## Upper Dearne Valley Environmental Trust (UDVET)

### CONSULTATION RESPONSE:

#### Application No. 2025/61/9026E:

#### Proposed Development, York House, Barnsley Road, Denby Dale

Appendix 6: Arboricultural Implications Plan

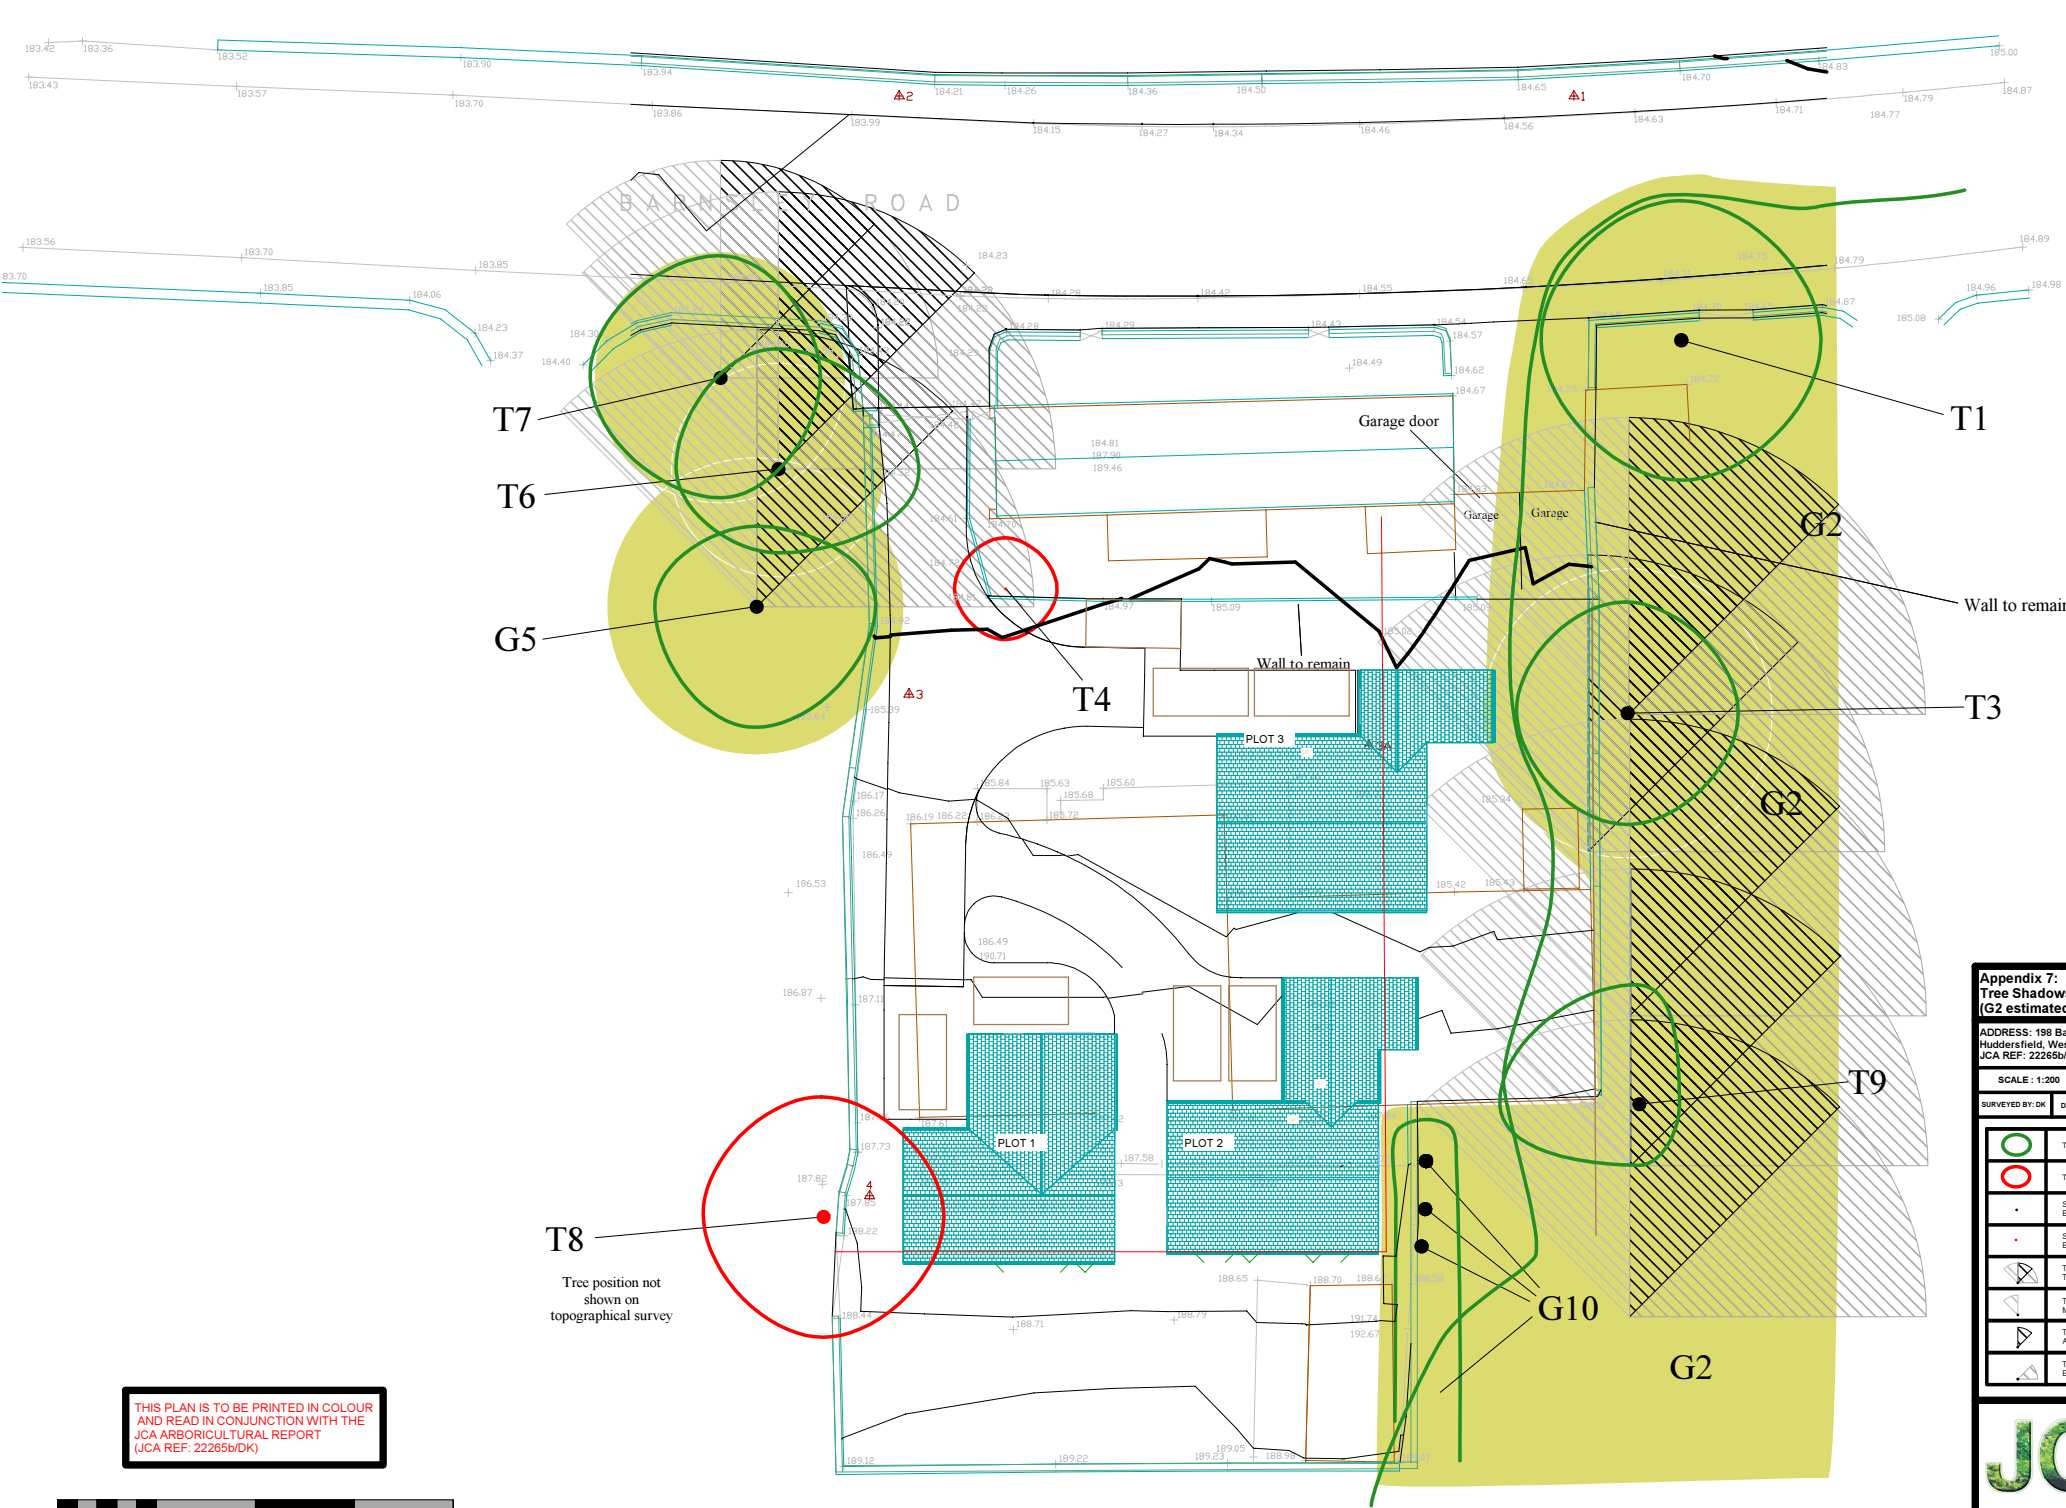
- This site is in an area where the trees are part of a group TPO. We **STRONGLY OBJECT** to this proposal in that it will lead to the felling of protected trees (especially T8). Despite the mitigation measures suggested by the consultants, it is also highly likely any development will cause root damage to other TPOs as strict supervision and enforcement of any measures to protect them cannot be guaranteed during demolition and rebuilding work. The latter poses many risks to the existing trees.

- Furthermore, the proximity of Plot 3 to T3 is not only likely to cause severe root damage, but is likely to come under pressure for future removal from any new resident and their insurance company (as we have recently seen in Skelmanthorpe).
